Certificate of Occupancy

LOCATION 115 Huntington Ave. CBL# 413-B-002

DATE: April 22, 1999

RE: Request for Certificate of Occupancy
115 Huntington Ave (lot 2, Copley Woods Circle)

copley woods lot 2
plot plan 1" = 20'

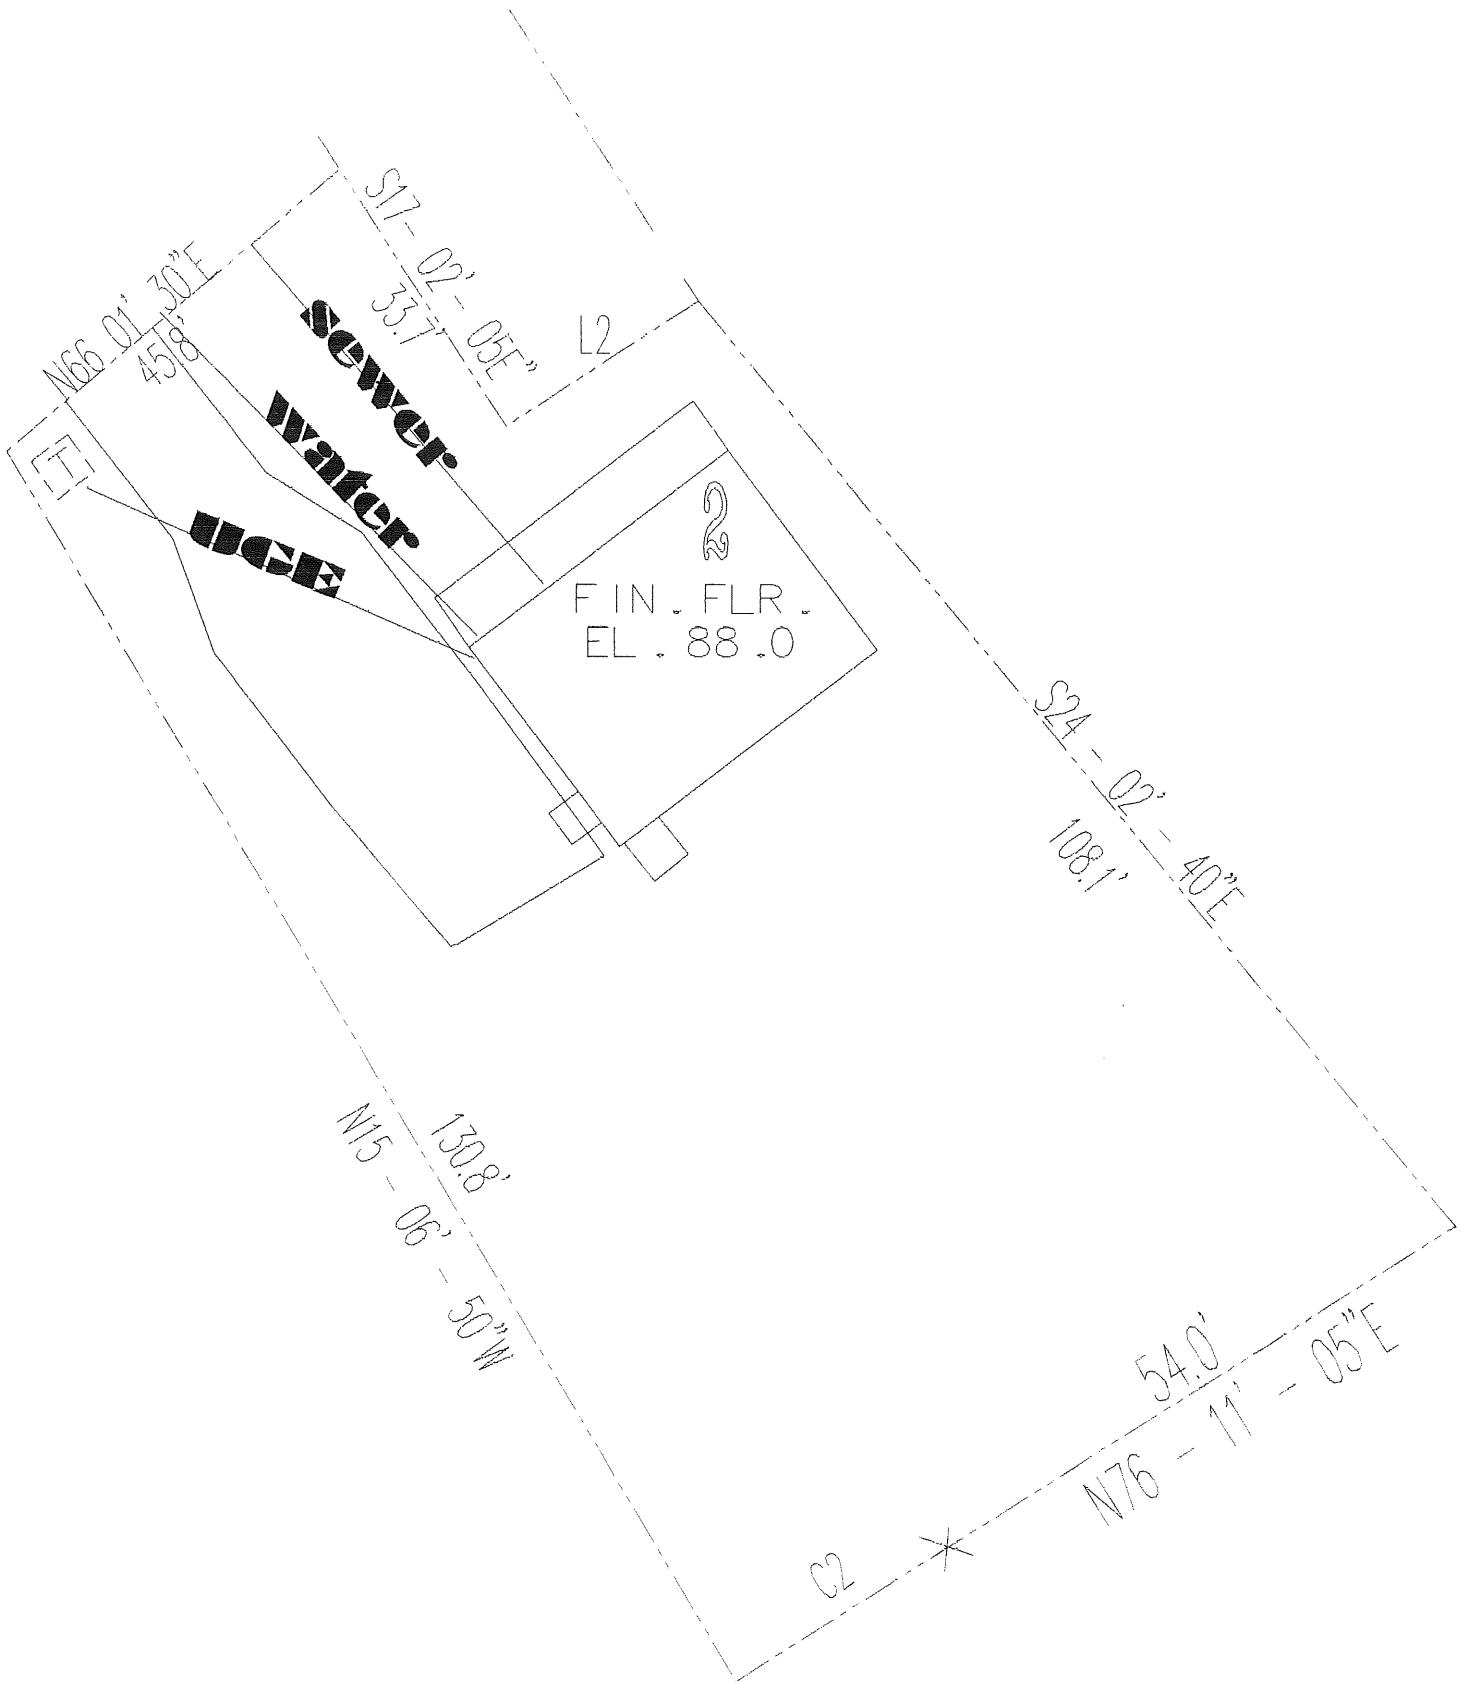
1. The landscape work could not be completed due to the time of year. This work must be completed by May 28, 1999.
- ~~2. There is currently no number on the house. Done 5/10/99~~
3. Final grading is needed to alleviate low spots around the basement bulkhead and certain points around the house. This includes the vicinity of the front porch, which currently appears to drain toward the foundation; as well as the lot to east which, although not under construction, appears to flow toward the foundation as well.
4. There is no evidence of a driveway.
5. Drainage from the turnaround toward the road, across the front of the property, appears to flow to the street.
